D. Dis. 41/17425/89

26-4-90.

Sub: MMDA - Planning permission - Construction of
Residential building in Plot No.8, at S.No.77/1A1
of Ullagaram village - Approval - Regarding.

site plan SCALE: 1" = 16' 0" (1:200)

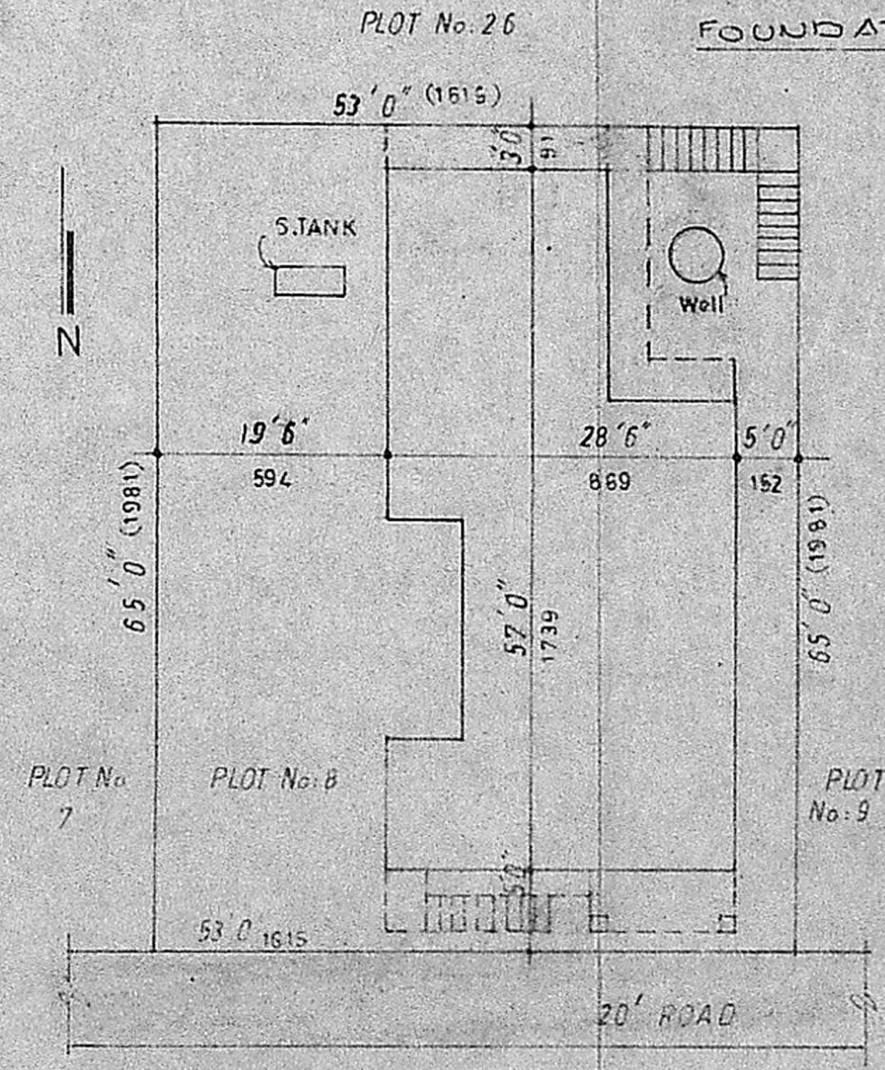
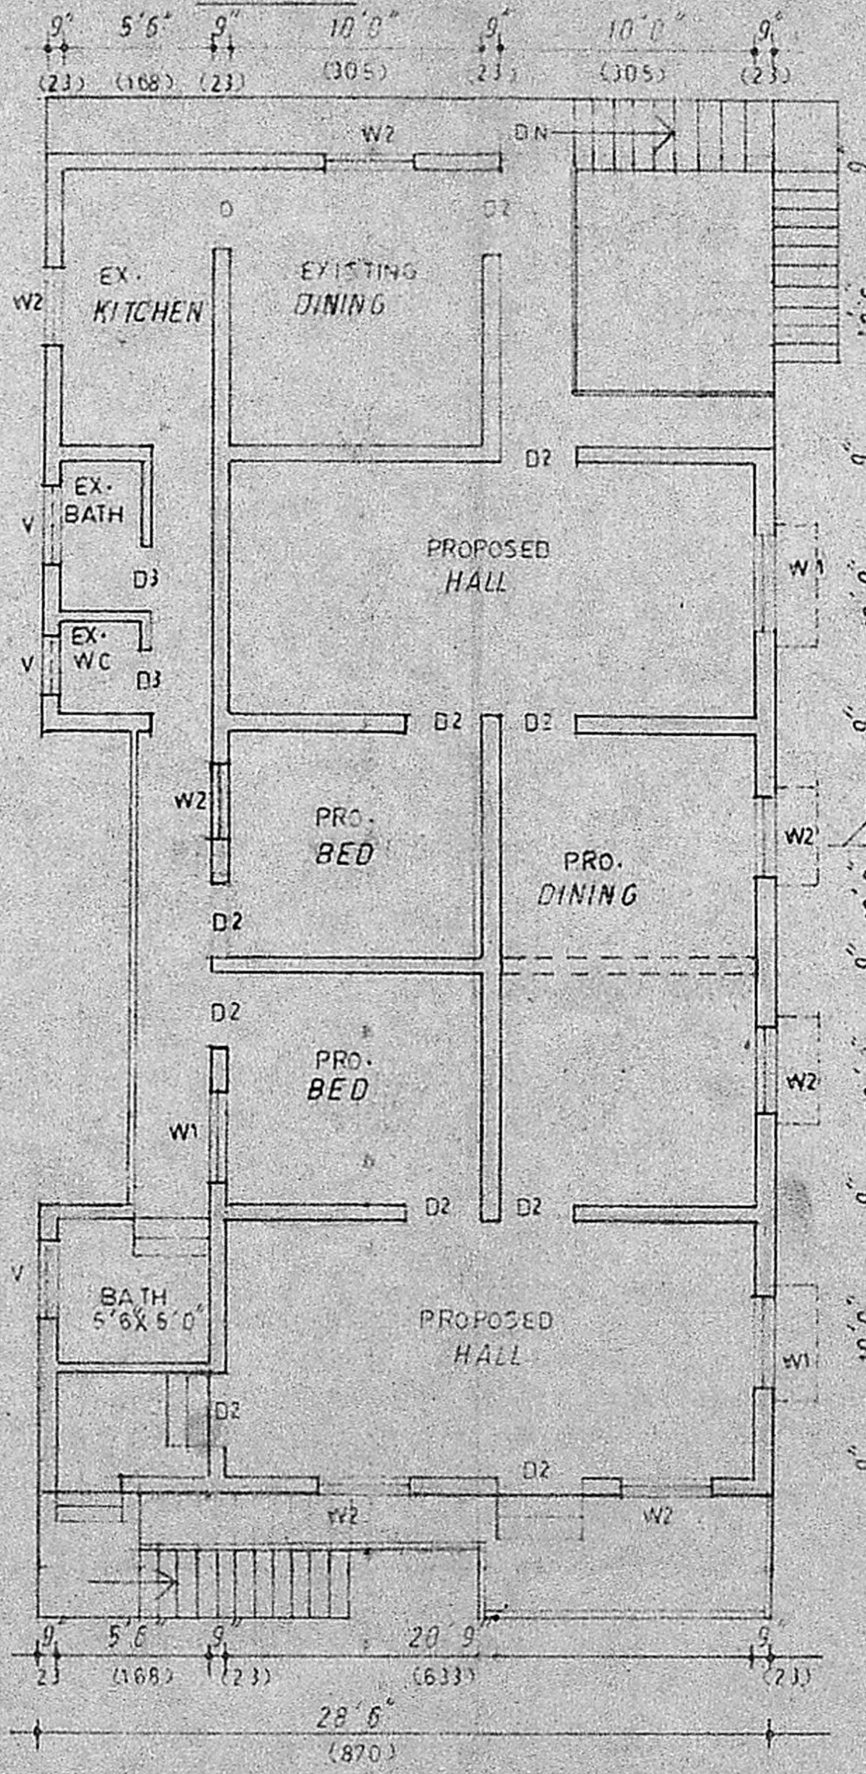
subject to condition that the structure
existing in the rear set back to a depth of 3.0 Mt. would be
demolished if there is any objection from the rear plot owner.
in the open space within the site to the extent
feasible trees be planted and the existing trees
preserved'
